KIRKLEES METROPOLITAN COUNCIL INVESTMENT & REGENERATION SERVICE

DELEGATED DECISION TO DETERMINE PLANNING APPLICATIONS

Reference No:	2025/62/93215/W
Site Address:	Land off, Slaithwaite Gate, Scapegoat Hill, Huddersfield, HD7 4NS
Description:	Change of use from storage to holiday let including single storey extension to the northern elevation and associated alterations
Recommending Officer:	Joanna Rednall

Title
 Planning Drawing.

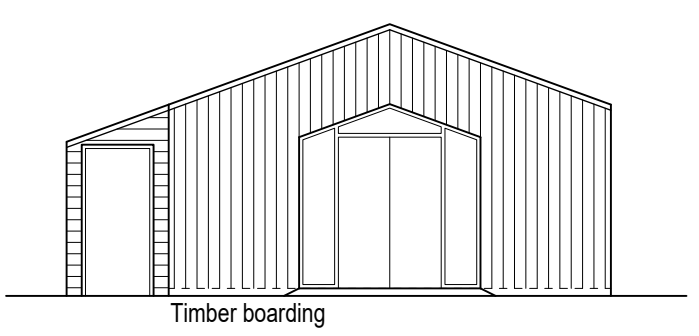
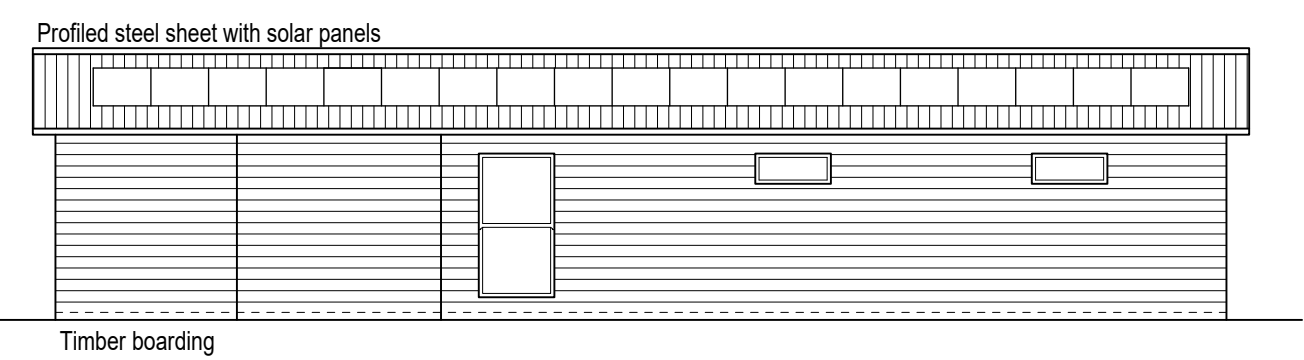
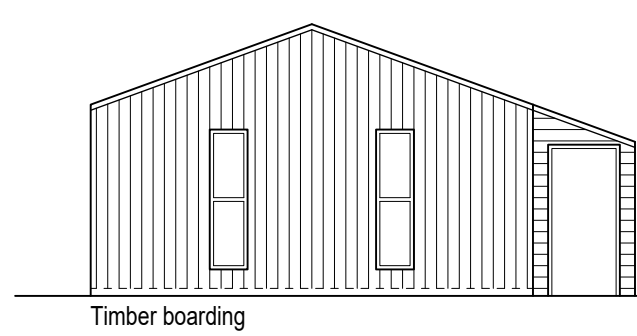
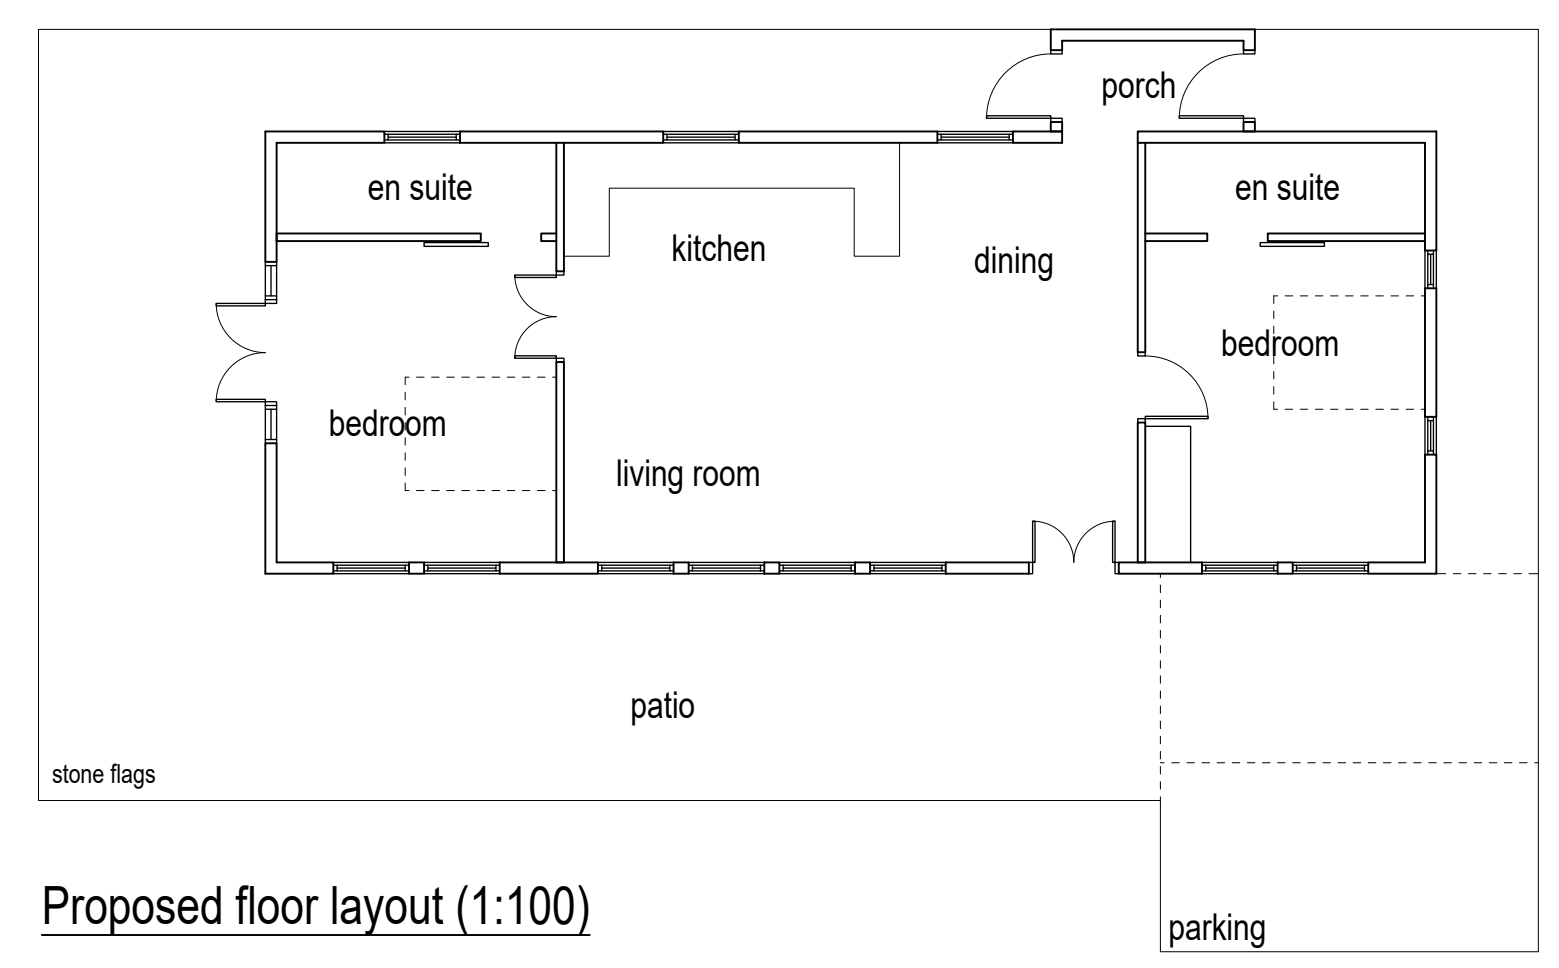
A lean-to extension is proposed to the rear elevation, projecting 1.5m and measuring 2.8m in width. It would have an eaves height of 2.2m and a maximum height of 2.7m to the ridge.

The window openings would be altered and enlarged to the front elevation, three new openings are proposed to the rear elevation, patio doors are proposed to the side/south facing elevation, and two windows are proposed to the north facing side elevation.

In respect of the fenestration, the enlarged openings would introduce a more domestic appearance. However, given the building's simple and functional form, these changes would not appear unduly prominent or out of character. The extension would clearly remain subordinate to the host building in terms of its scale and design. Overall, the proposal is considered acceptable in design and visual terms.

3. The external walls and roofing materials of the extension hereby approved shall in all respects match those used in the construction of the existing building.

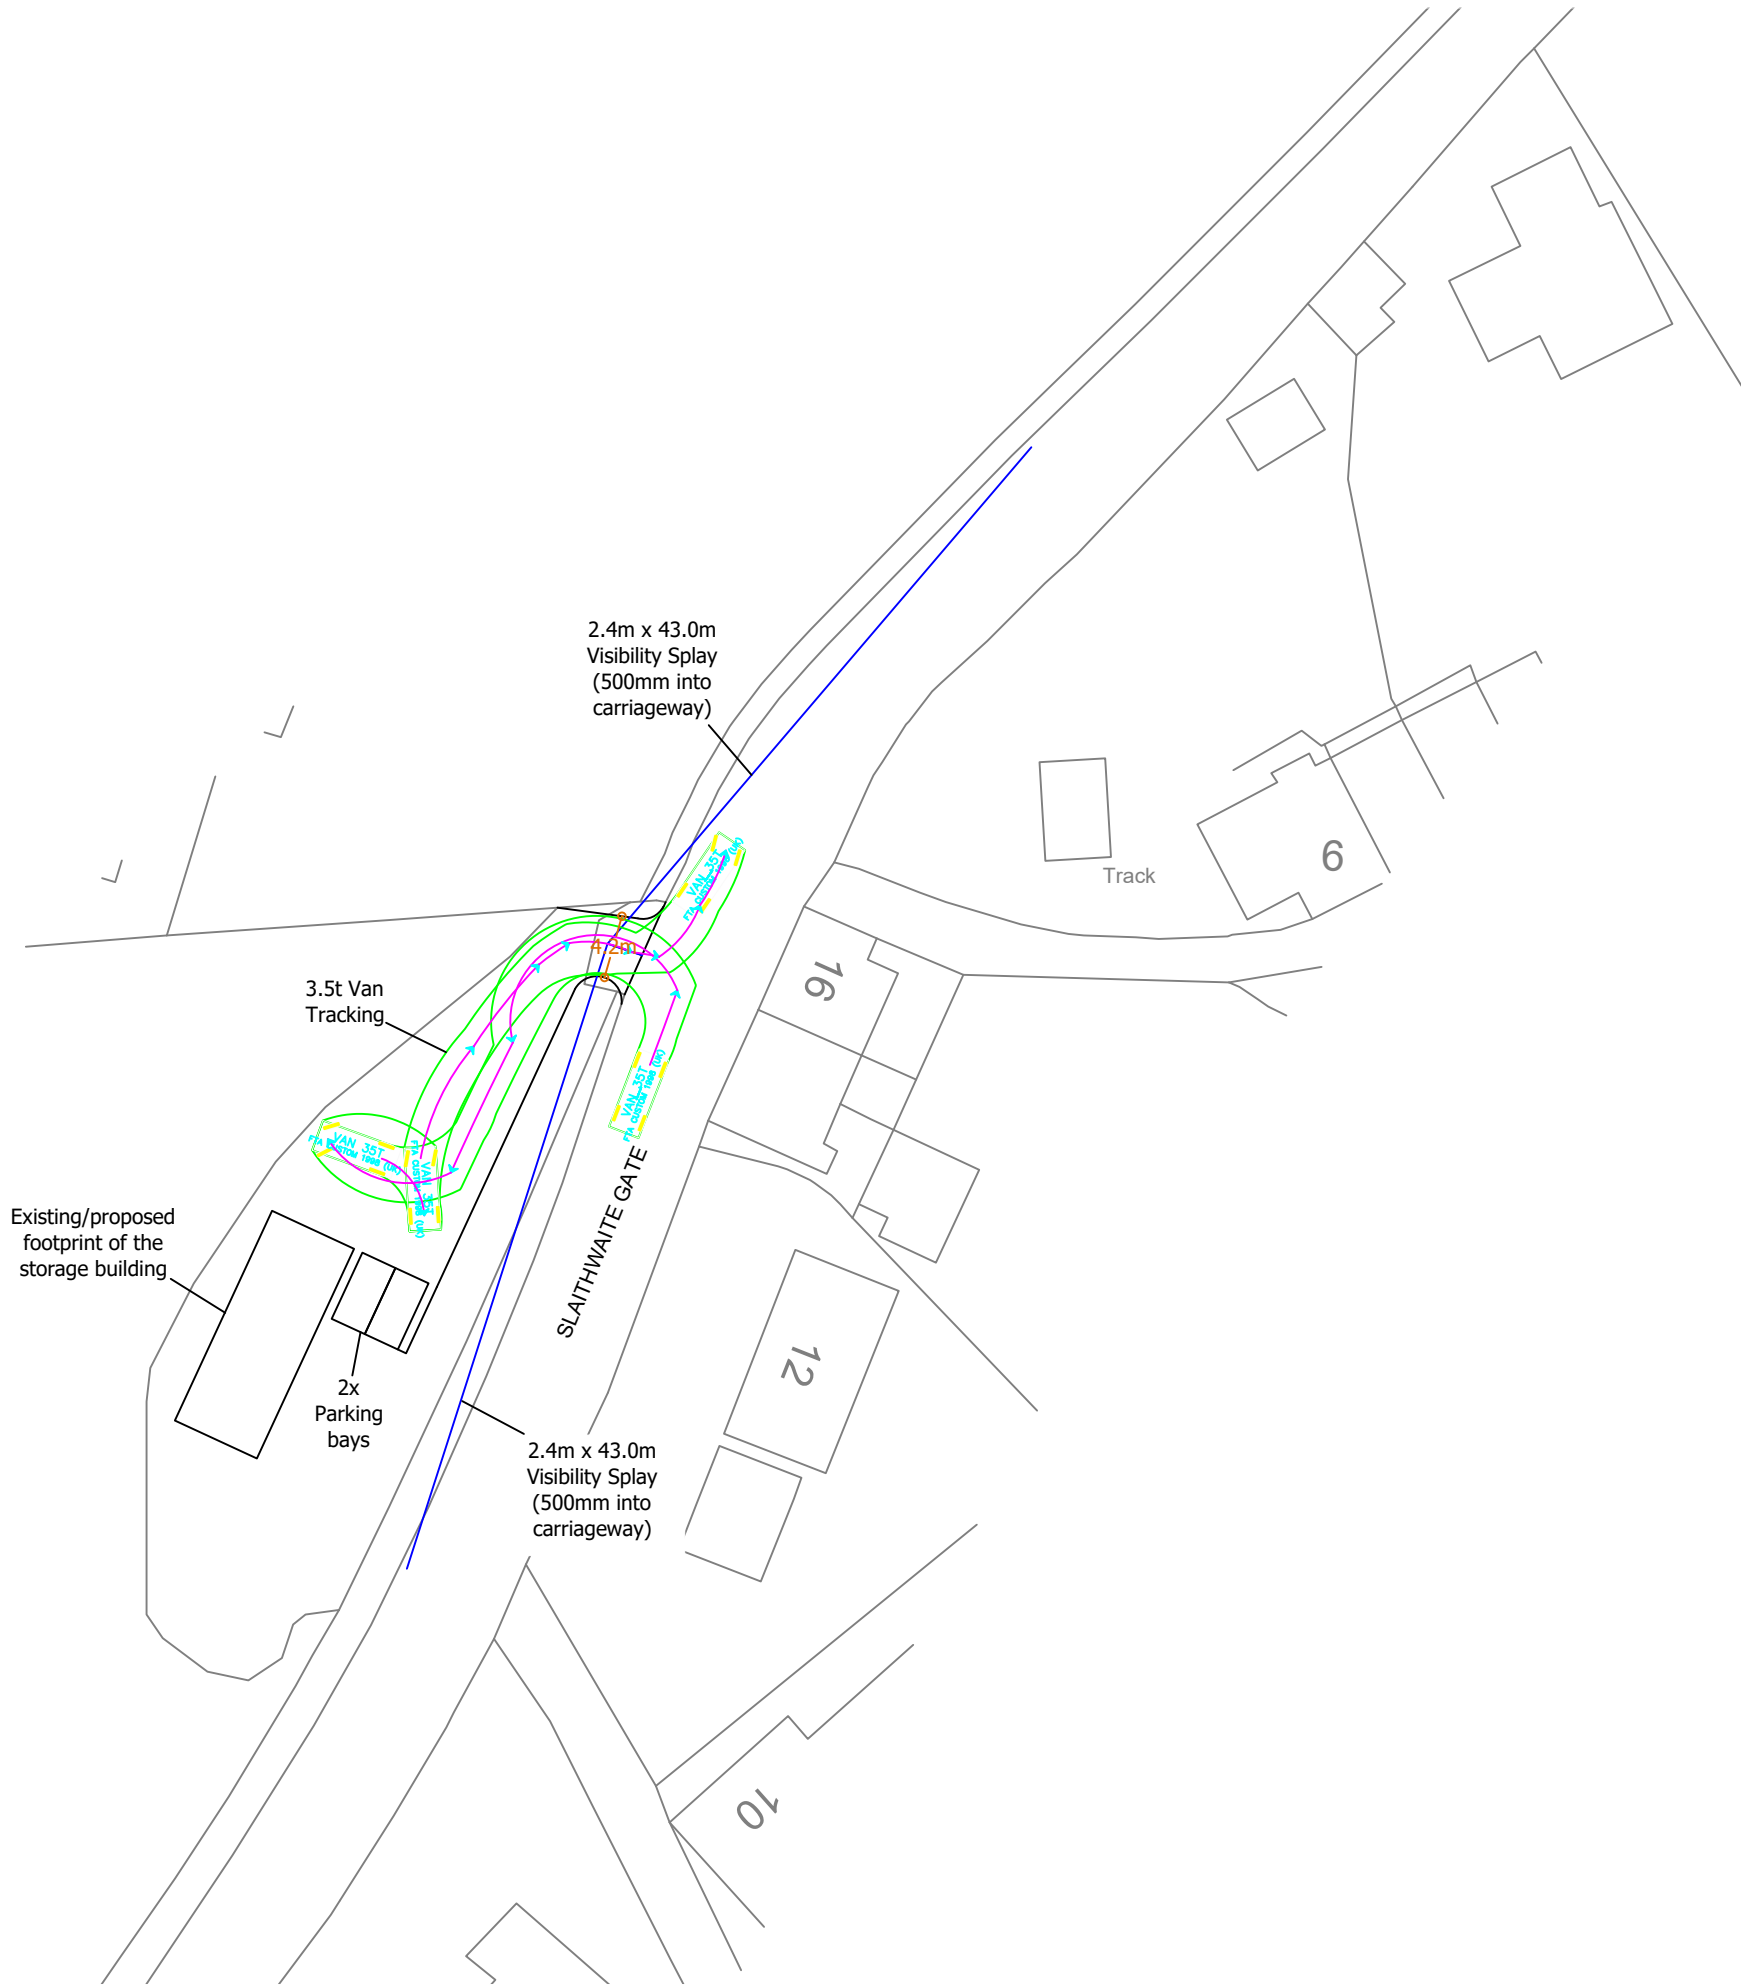
Officers requested additional information regarding sight lines, turning areas, and parking provision. The submitted details demonstrate two parking spaces, adequate internal turning space, and a visibility splay measuring 2.4 metres by 43 metres, extending 500mm into the carriageway. These arrangements are considered acceptable, subject to conditions requiring the visibility splay to be maintained clear of obstructions for the lifetime of the development.

5. Sight lines (2.4m x 43.0m visibility splays along Slaithwaite Gate) as indicated upon approved drawing no. PRGN-2301-HGN-DR-CH-0001 'Preliminary Access Proposal' shall be retained, unobstructed, for the lifetime of the development.
